Application No: A/28/22/HH
Site Address: 27 Beech View Angmering BN16 4DE
Description of works: Single storey mono pitch roofed extension. Single Storey front extension and conversion of garage to habitable use.

Thank you for your internet representation made on 31st March 2022 which has been recorded as an objection with the comments as follows:

PROPOSED FRONT ELEVATION (1:100) (WEST)

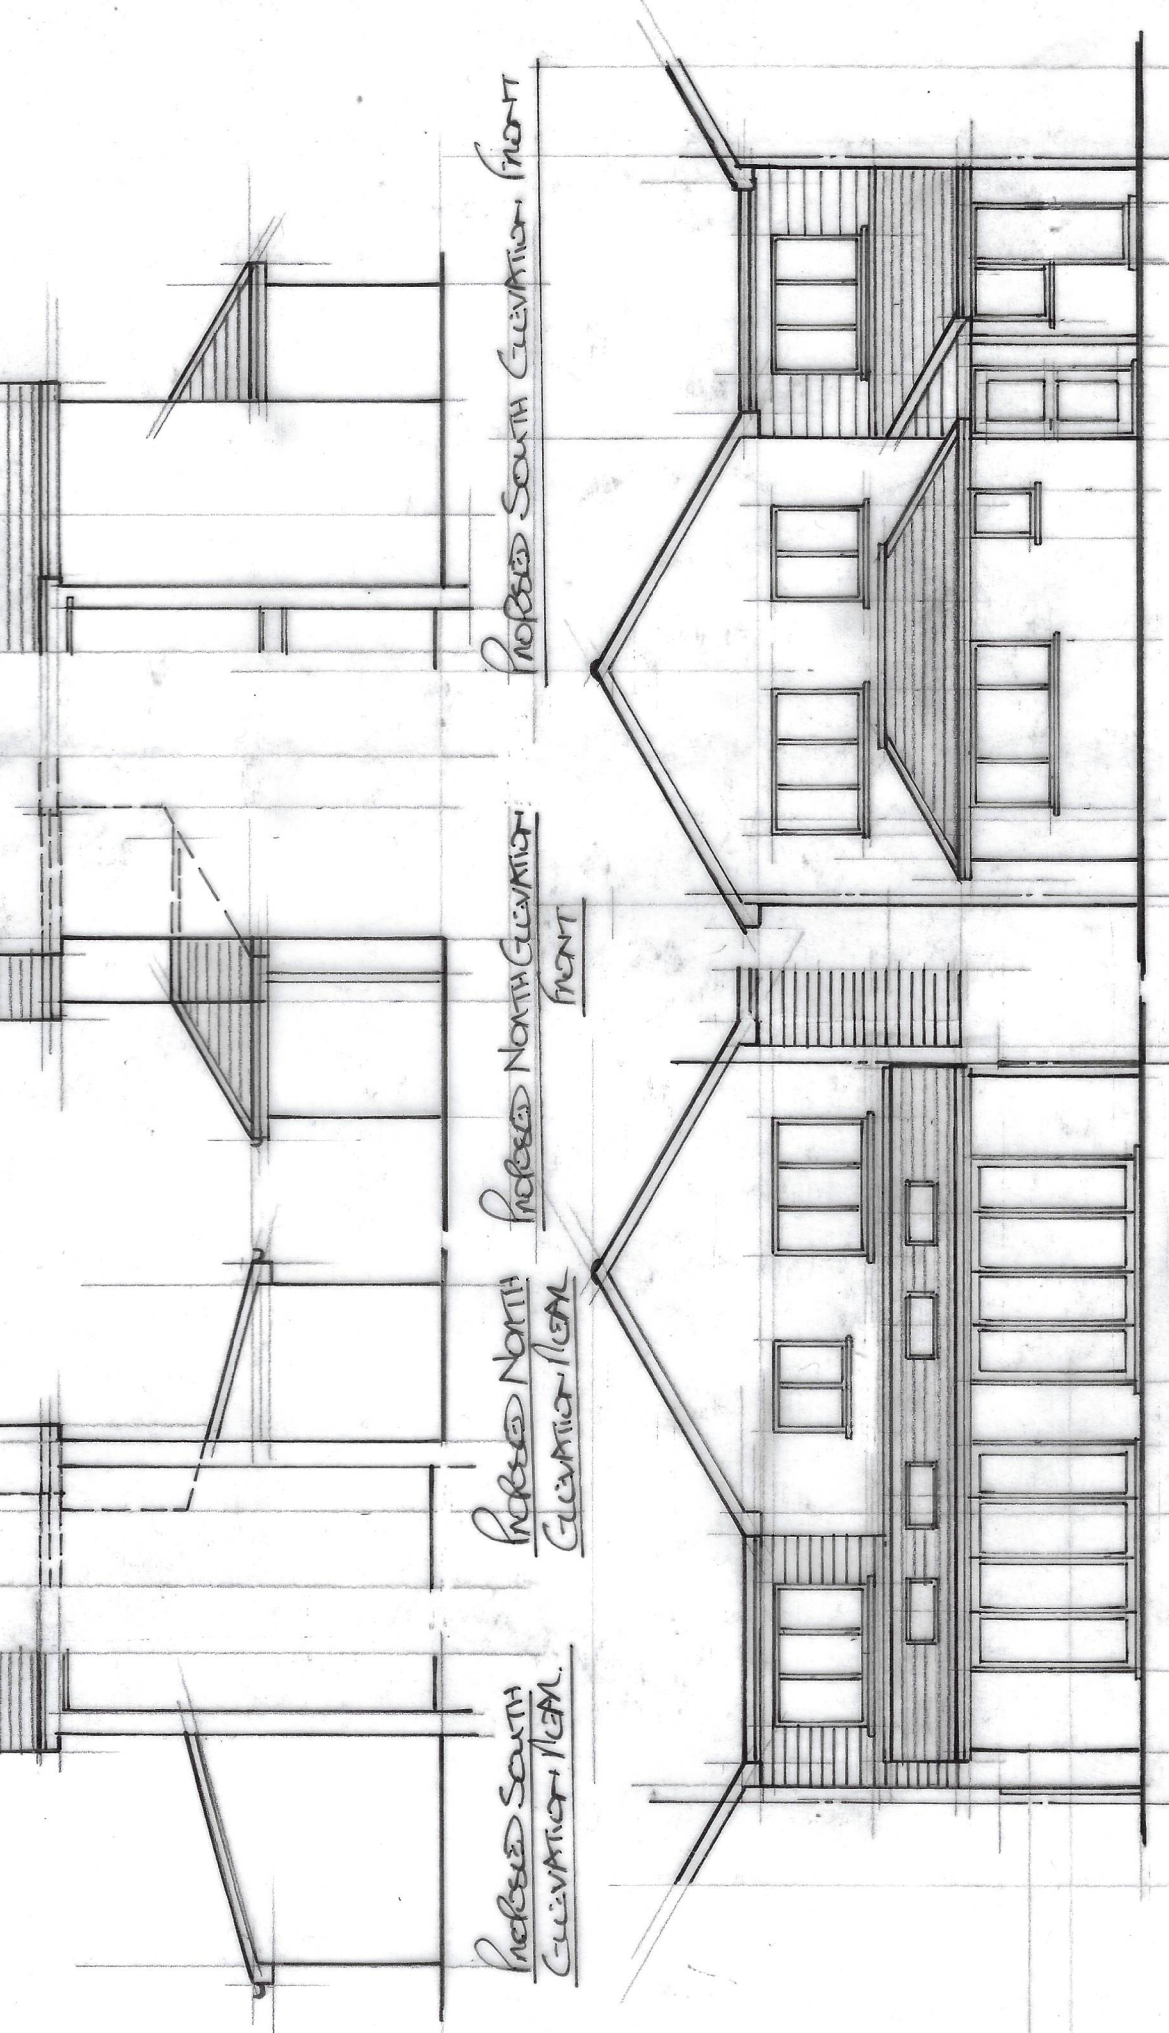
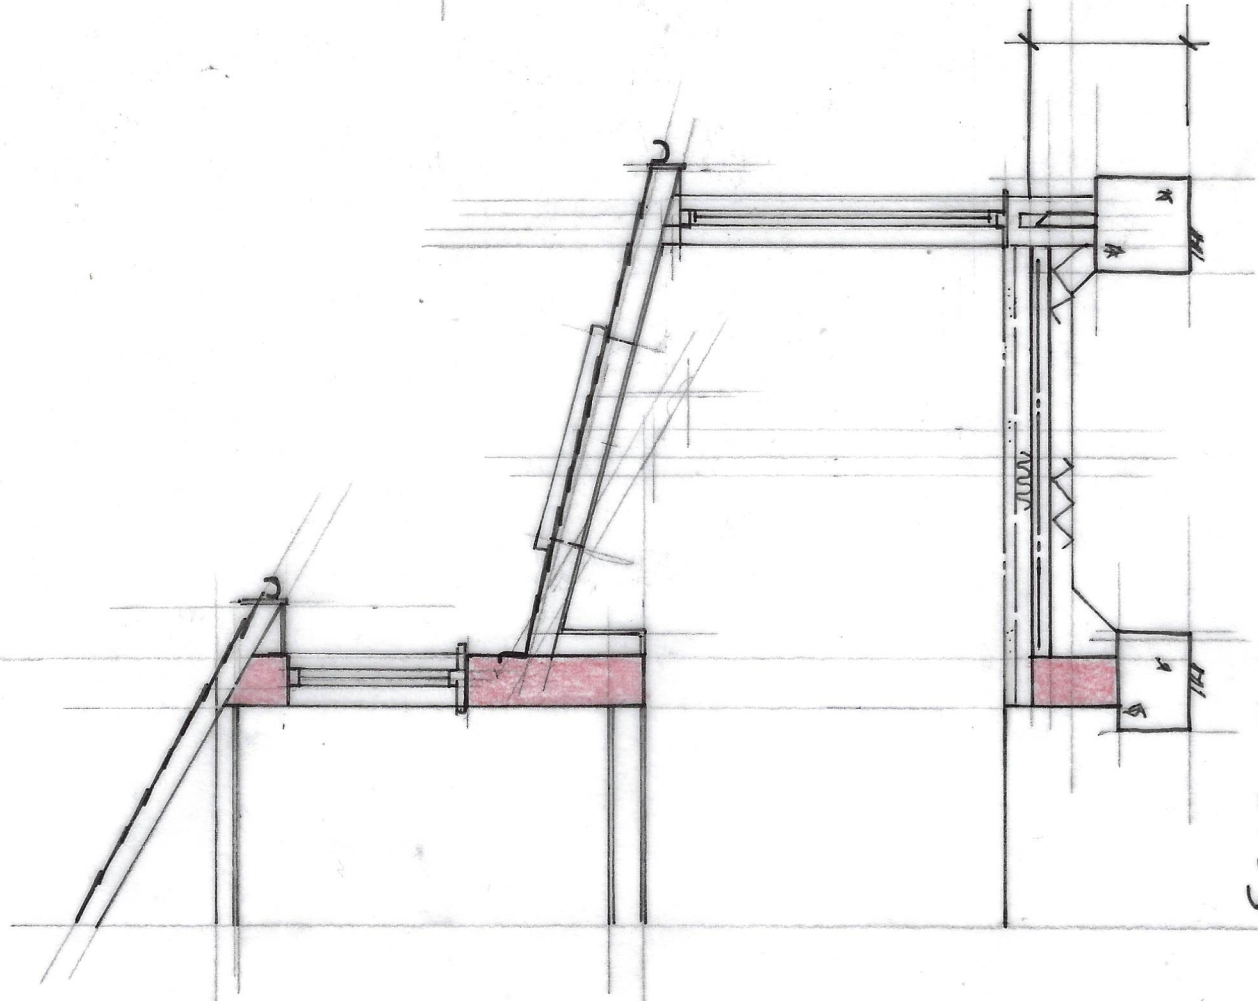
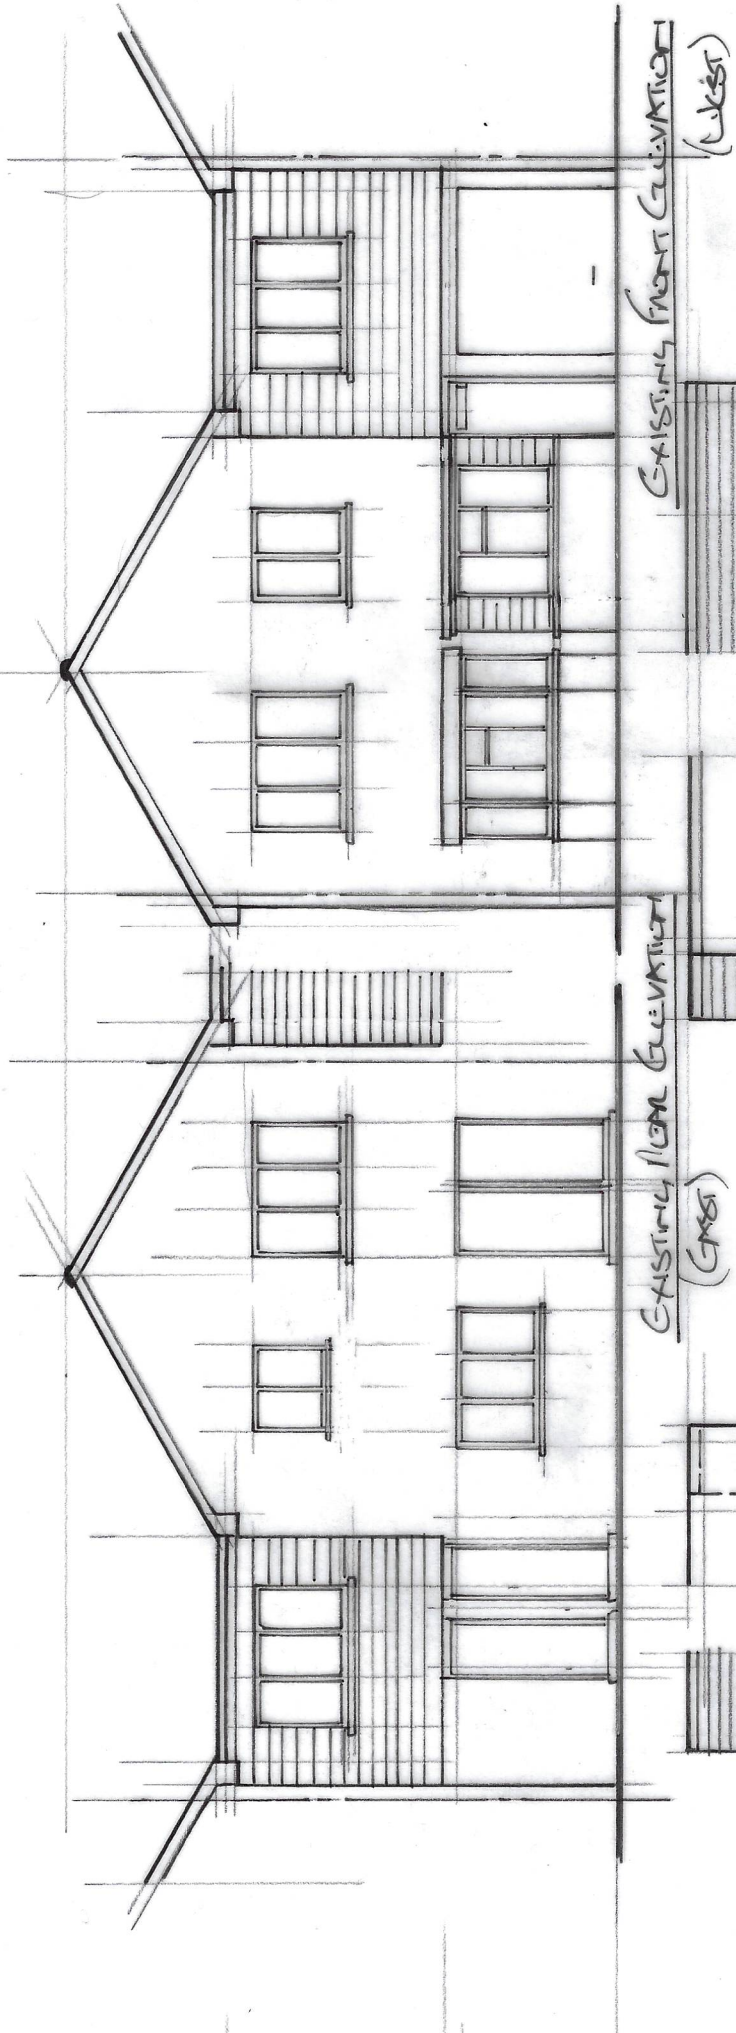
The proposed application represents overdevelopment of the site with the front extension projecting in front of the building line. The reduced parking provision is likely to lead to on street parking with potential highway safety issues.
